February 16, 2022

Please add PCD File #MS-22-005

Re: Owl Ridge Minor Subdivision Letter of Intent

Final Plat

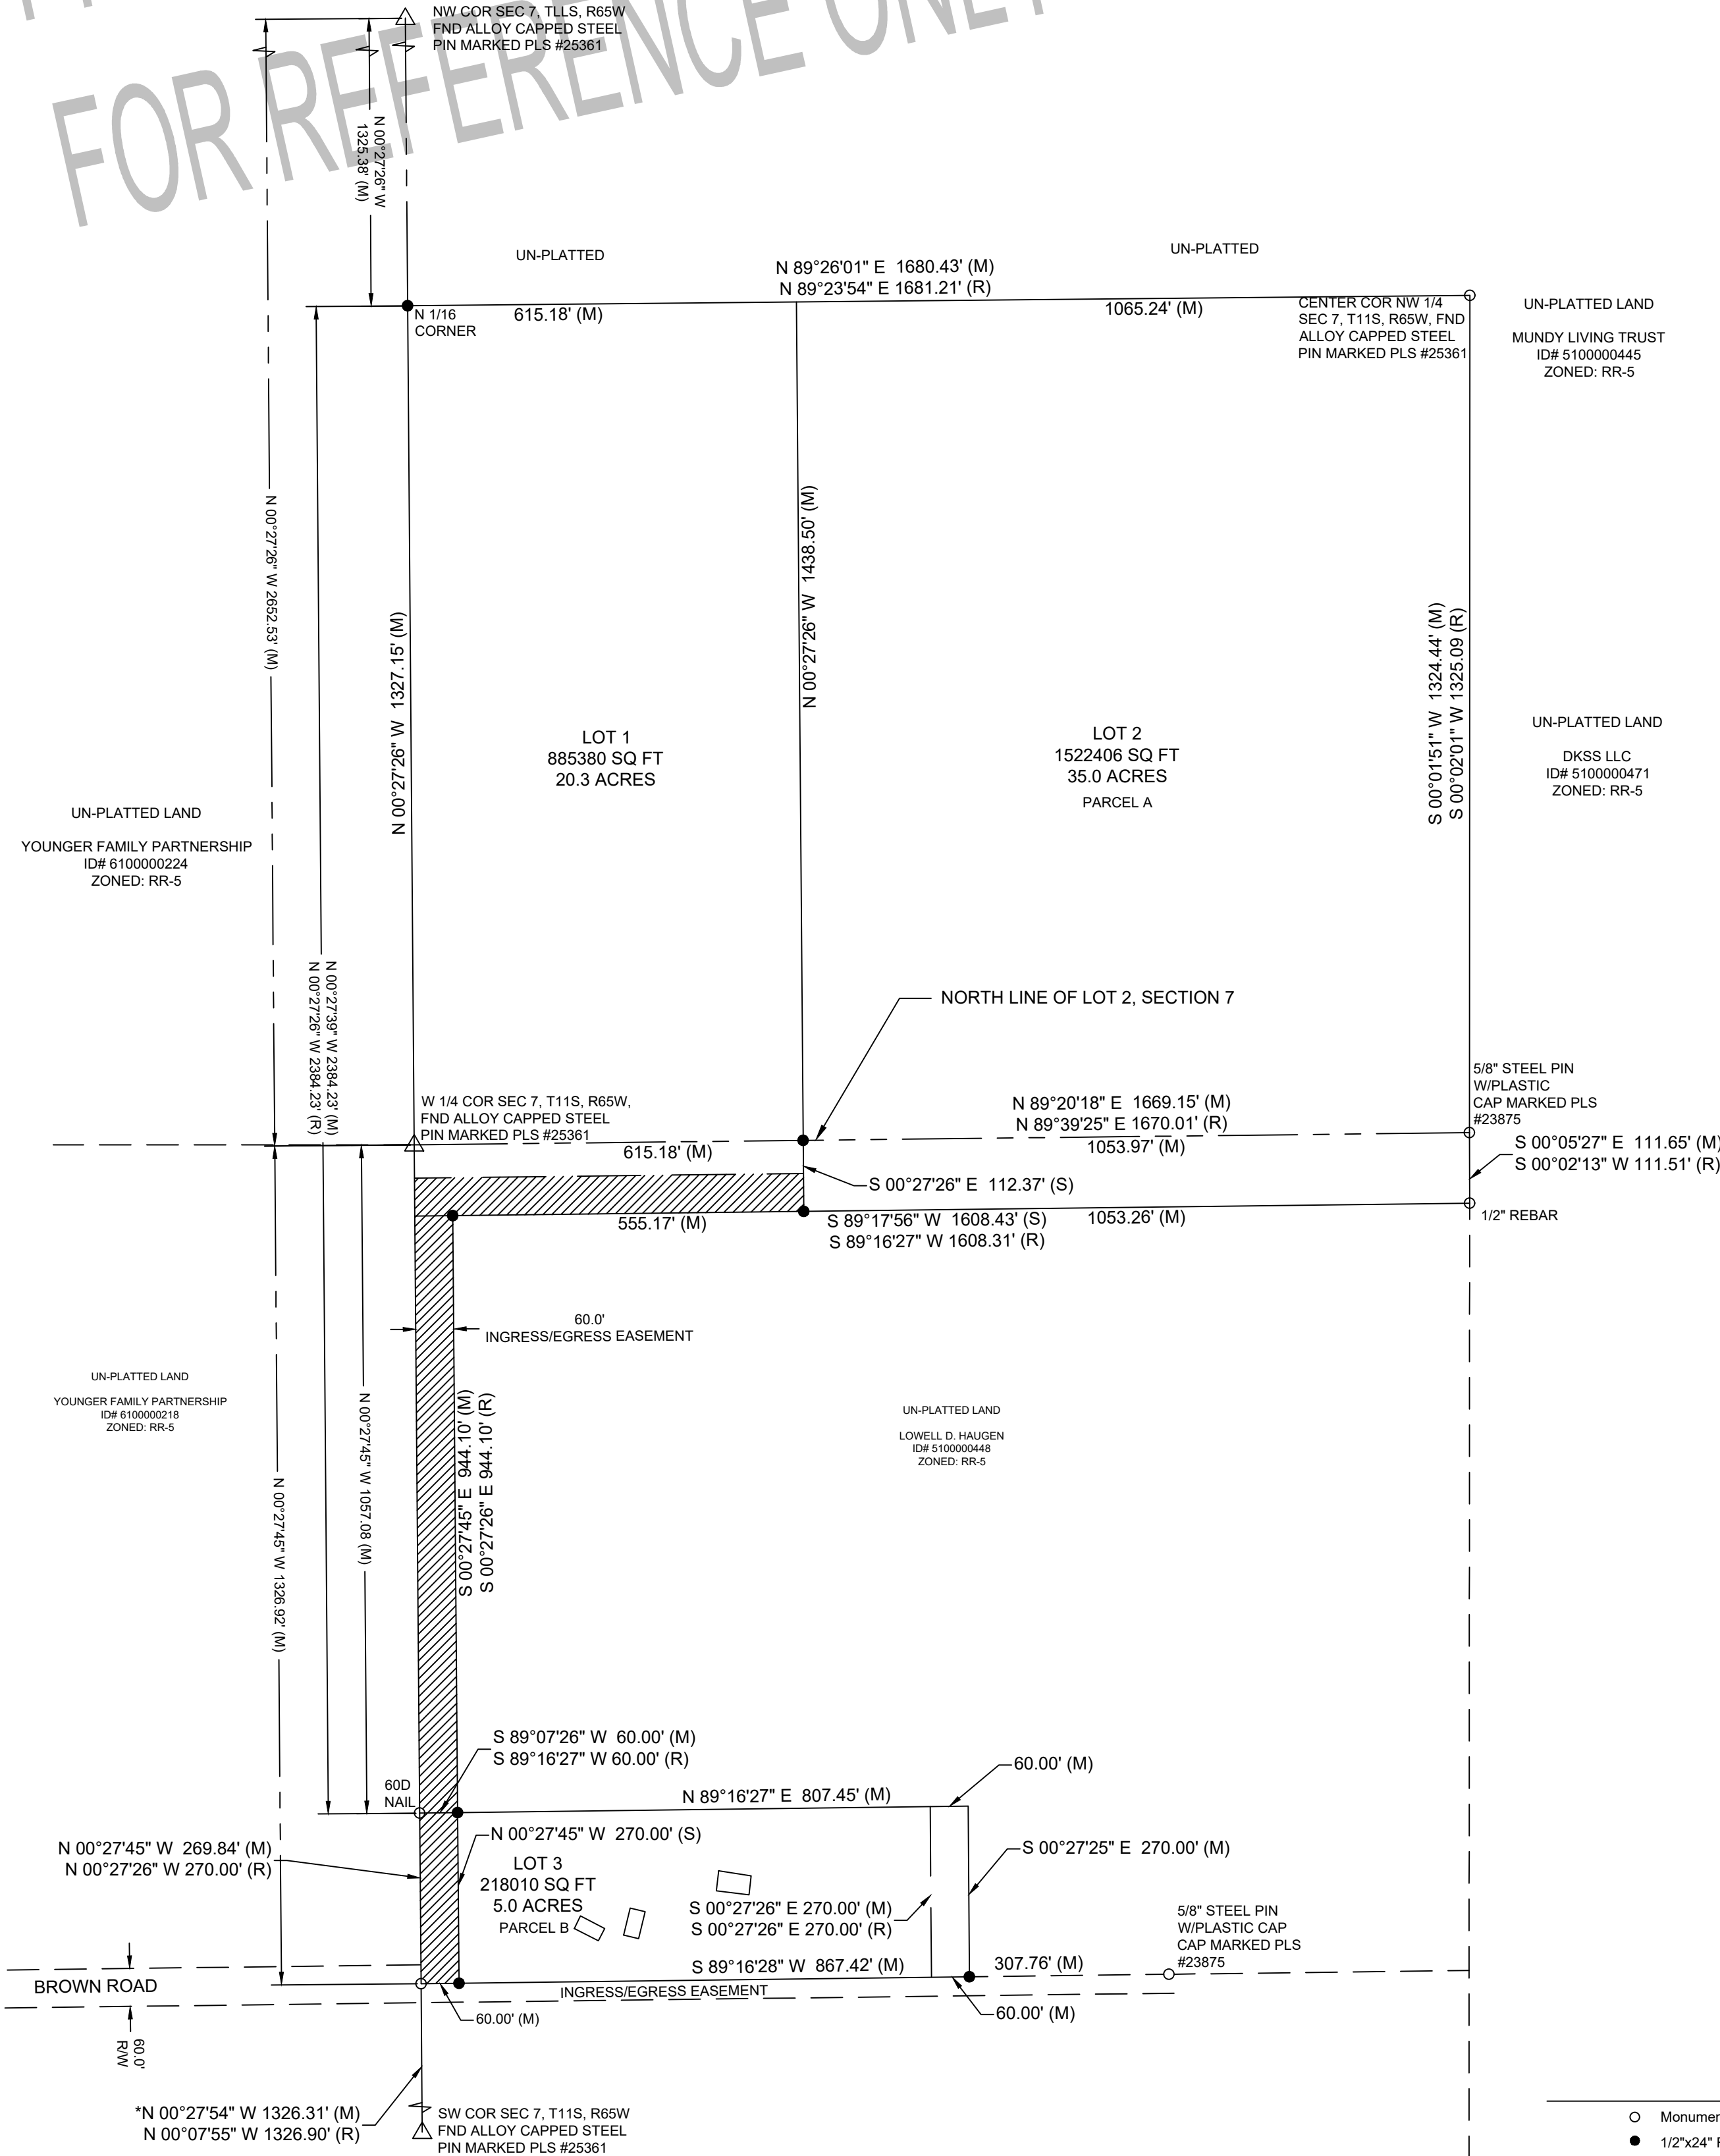
Discuss Right of Way along Brown Road. ROW will need to be dedicated for Brown Rd. See draft plat drawing.
